Planning Inspectorate
Arolygiaeth Gynllunio

Acceptance of Applications Checklist

Dean Moor Solar Farm Section 55 Acceptance of Applications Checklist

Client	
FVS Dean Moor Limited	
Title	
DEAN MOOR SOLAR FARM DEVELOPMENT CONSENT ORDER REGULATION 5(2)(I)(i) Statutory Sites	
Scale: 1:80,000 @ A3	Date: 07/03/2025
Drawn: TL	Checked: JL
Sheet 1 of 3	Rev: A

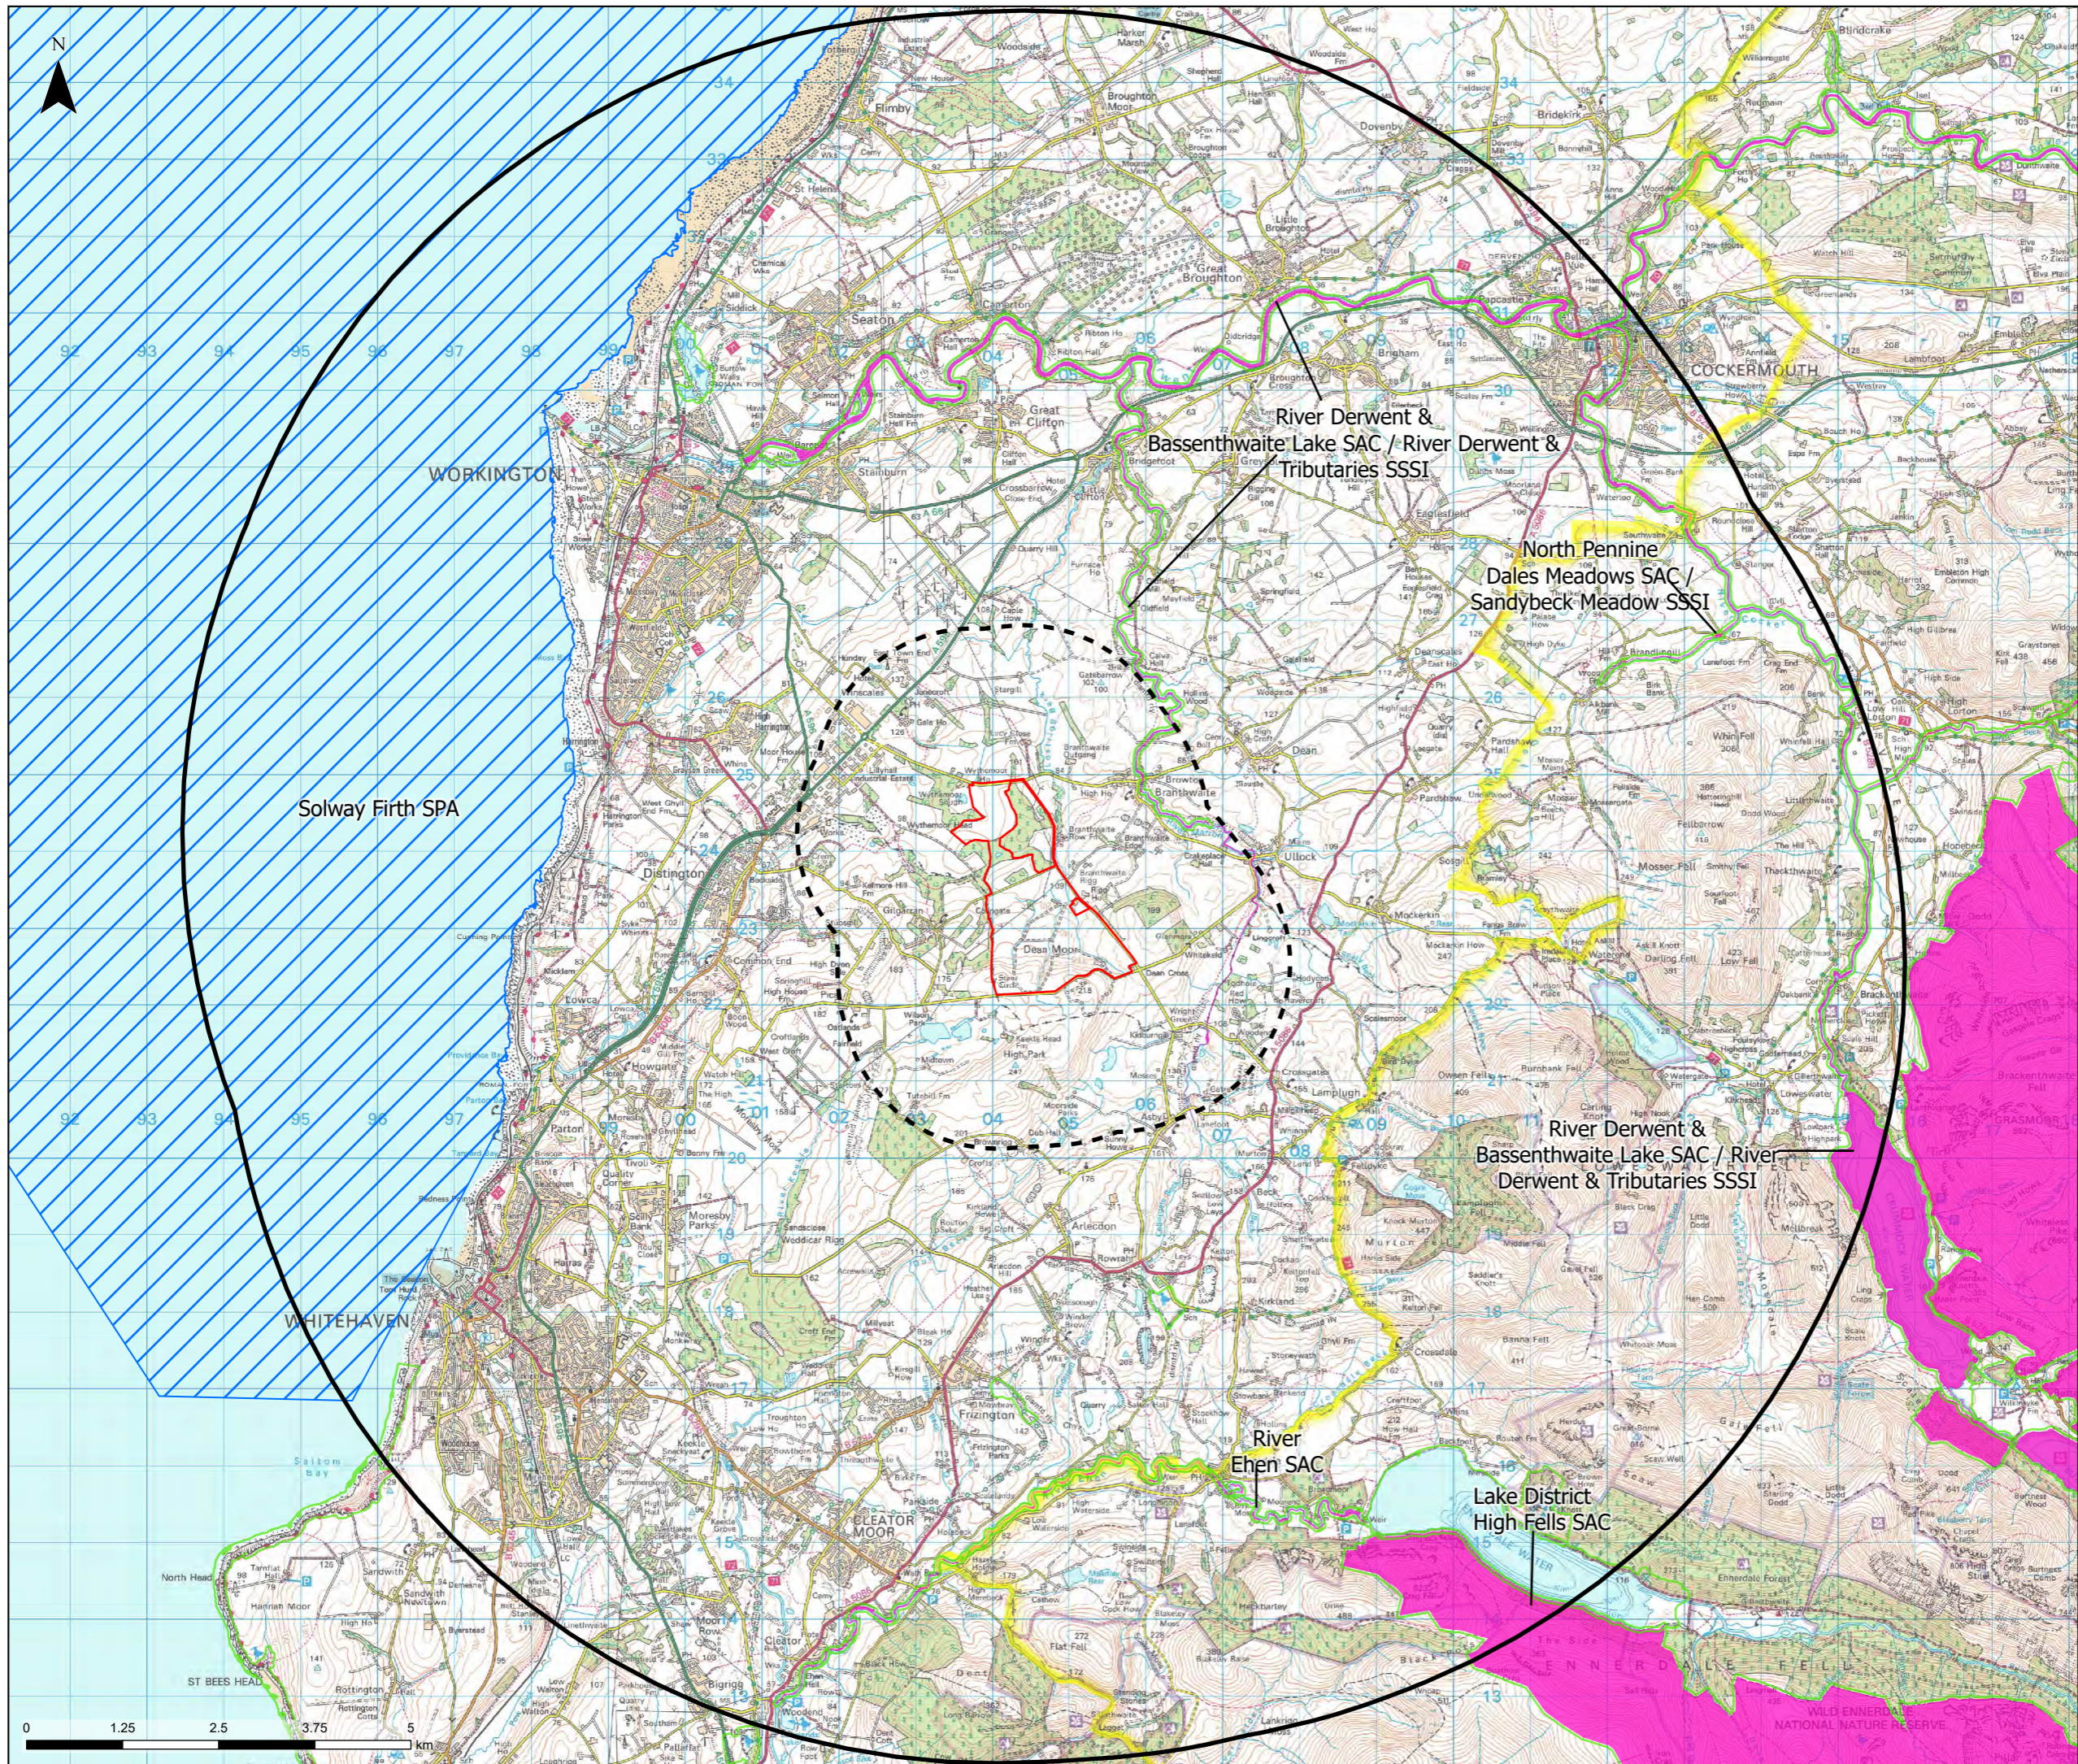
<ul style="list-style-type: none"> The applicant should ensure figures are clear as possible for the end user. Colour choices for the legend in ES Figure 8.1 are not easily identified and a substantial bleed has been included for the Lake District National Park making the exact border location unclear. <p>Non-Technical Summary (Doc 6.4)</p> <ul style="list-style-type: none"> Several of the Figures within the NTS do not match the corresponding ES Chapter Figures (Doc 6.2). This makes it more difficult to cross-reference material contained within the Environmental Statement and associated Appendices. <p>Section 51 advice has been issued to the Applicant in respect of the above matters: https://nsip-documents.planninginspectorate.gov.uk/published-documents/EN010155-000017</p>	
31	<p>In accordance with Regulation 5(2)(g) of the APFP Regulations, is the application accompanied by a report identifying any European site(s) to which Regulation 48 of The Conservation (Natural Habitats, &c.) Regulations 1994 applies; or any Ramsar site(s), which may be affected by the Proposed Development, together with sufficient information that will enable the Secretary of State to make an appropriate assessment of the implications for the site if required by Regulation 48(1)?</p>	<p>Yes</p> <p>A Shadow Habitat Regulations Assessment (HRA) Report (Doc 6.3) is provided at Appendix 8.7 of the Environmental Statement.</p> <p>The HRA Report identifies relevant European sites and the likely effects on those sites. It is considered that the information provided in the report is adequate for acceptance.</p> <p>Note: The Examining Authority may seek clarification during the Examination. This may result in additional information being required to inform the HRA Report and the competent authority. Depending upon the type and availability of information required it may not be possible to obtain this during the statutory timetable of the Examination.</p>

Client		
FVS Dean Moor Limited		
Title		
DEAN MOOR SOLAR FARM DEVELOPMENT CONSENT ORDER REGULATION 5(2)(O) Traffic Regulation Measures Plan Version 2		
Scale: 1:5,000 @ A3	Date: 04/06/2025	
Drawn: TL	Checked: TH	
Reference: 2.5	Sheet 1 of 1	Version 2

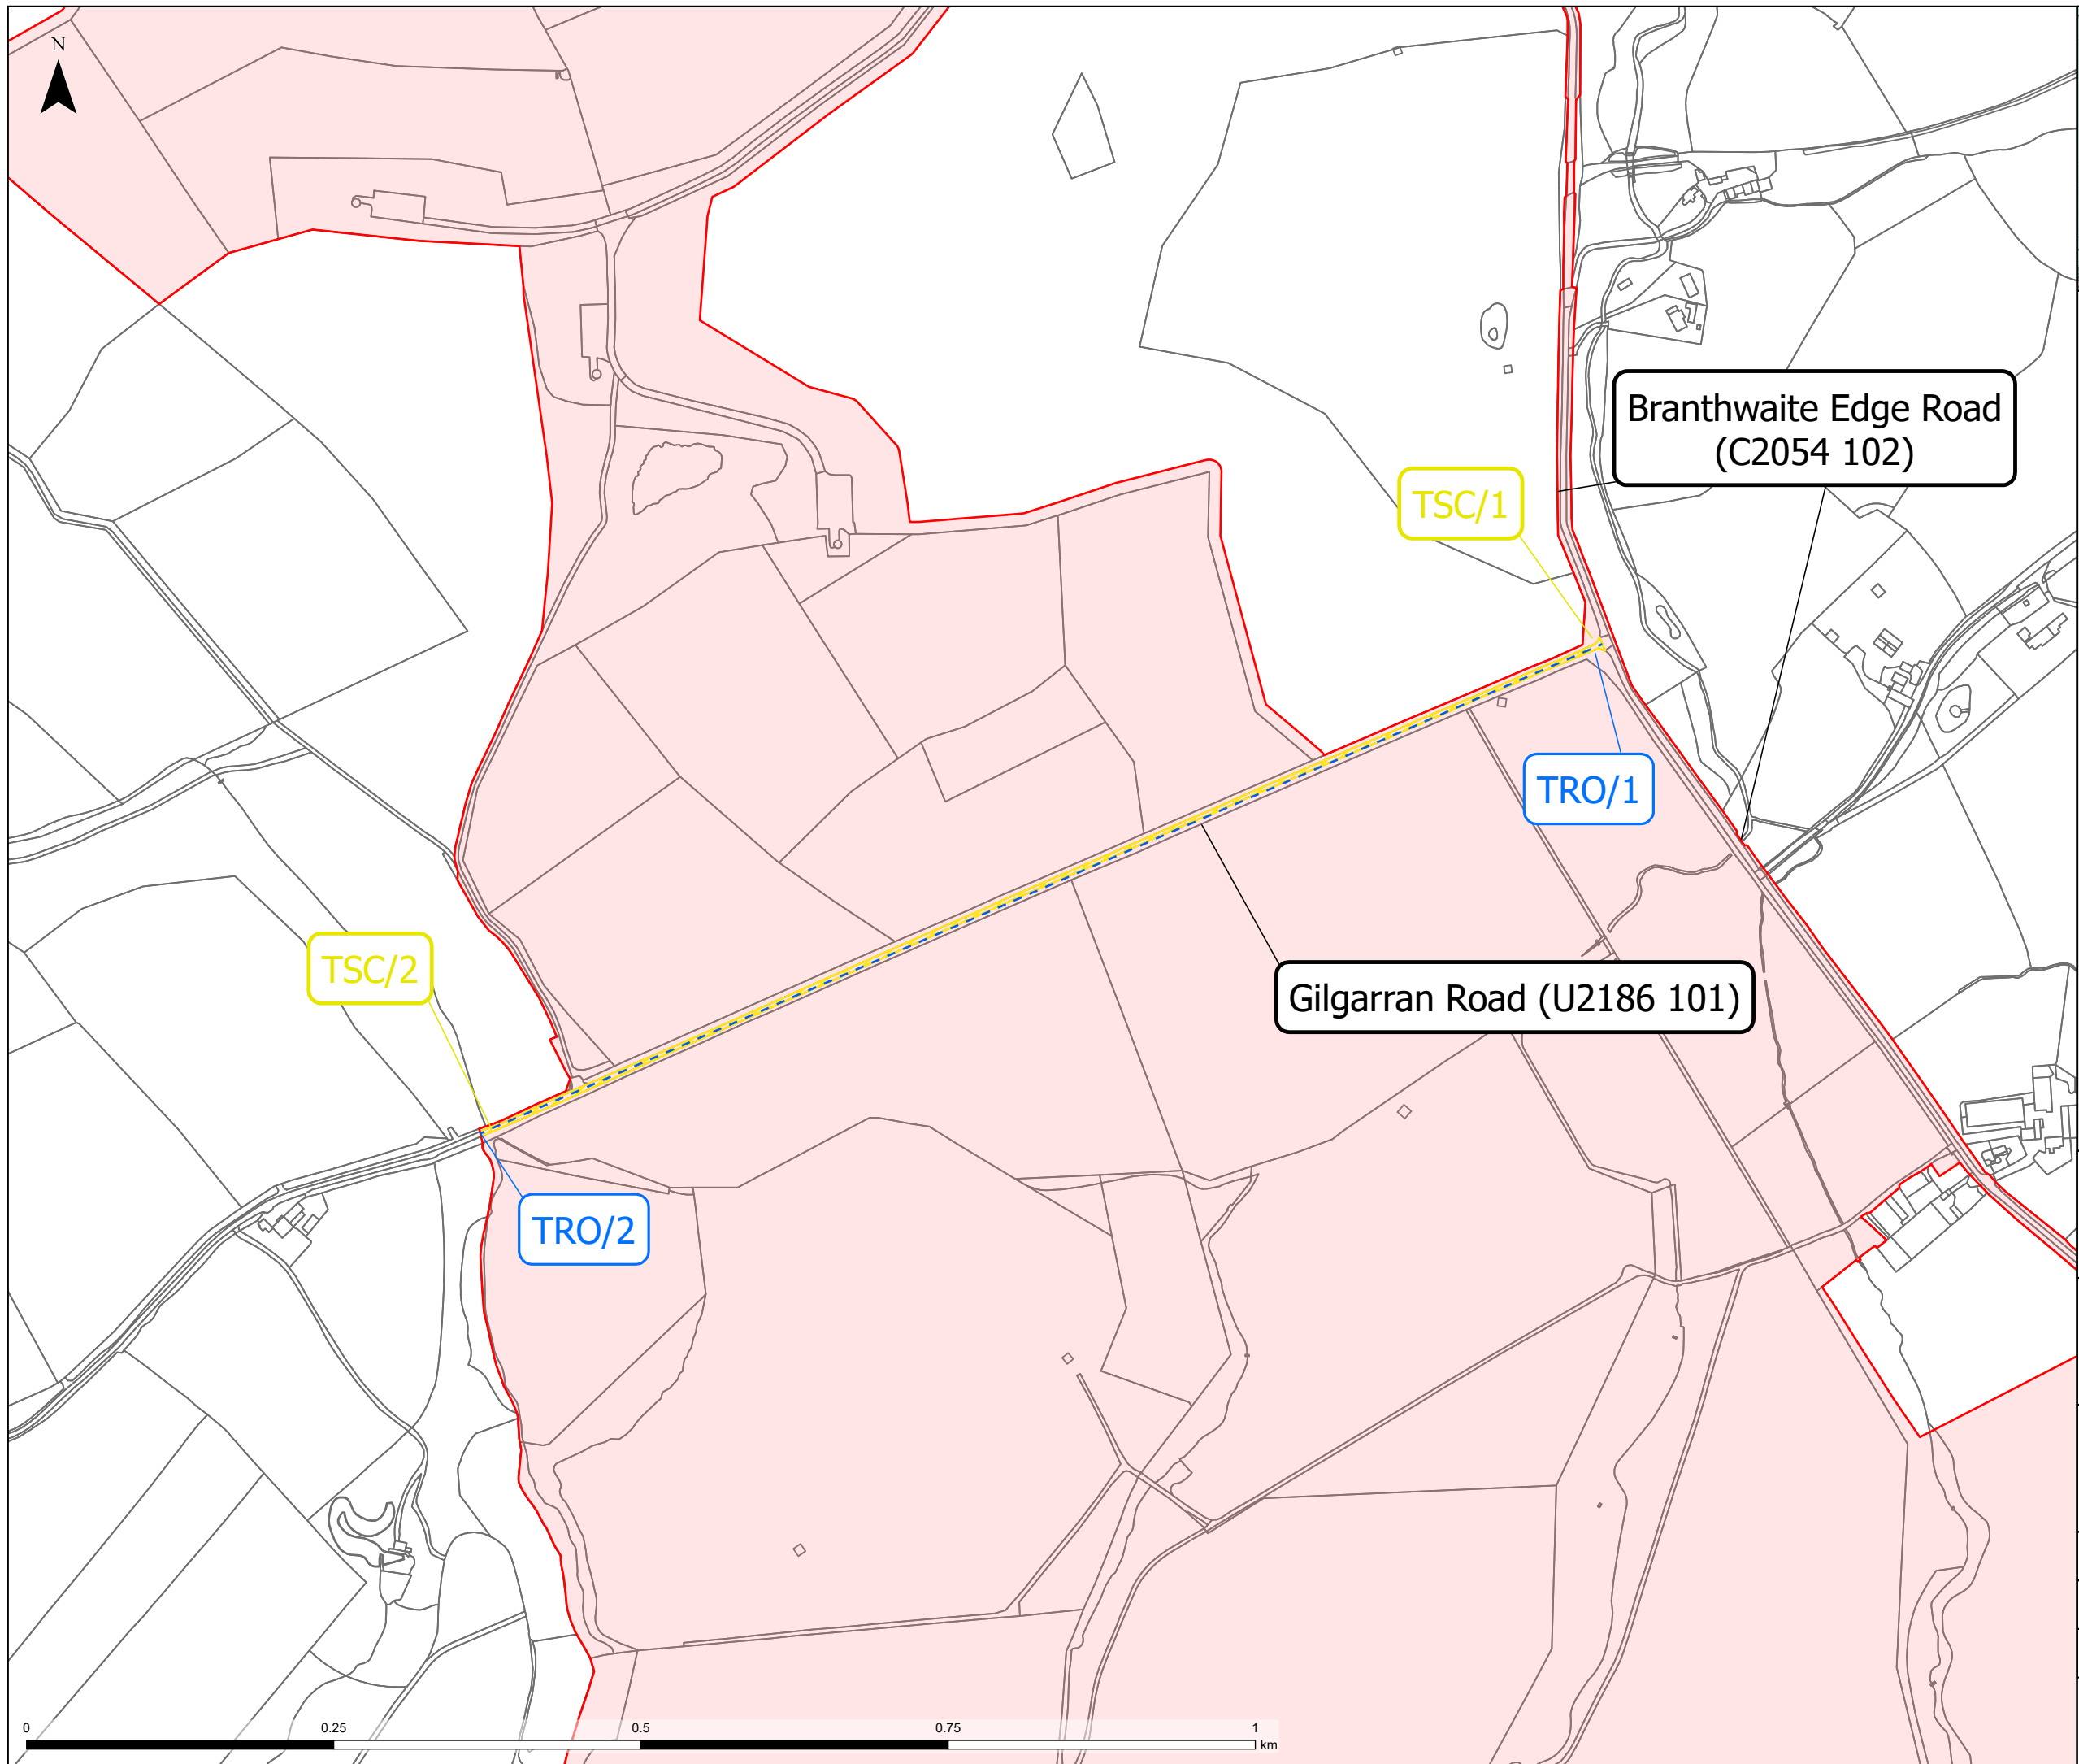
- The plan does not have any road names as identified in the dDCO.
- Schedule 6 of the dDCO states points TSC/1 and TSC/2 are hatched yellow on the plan, but the colour on the plan is orange.
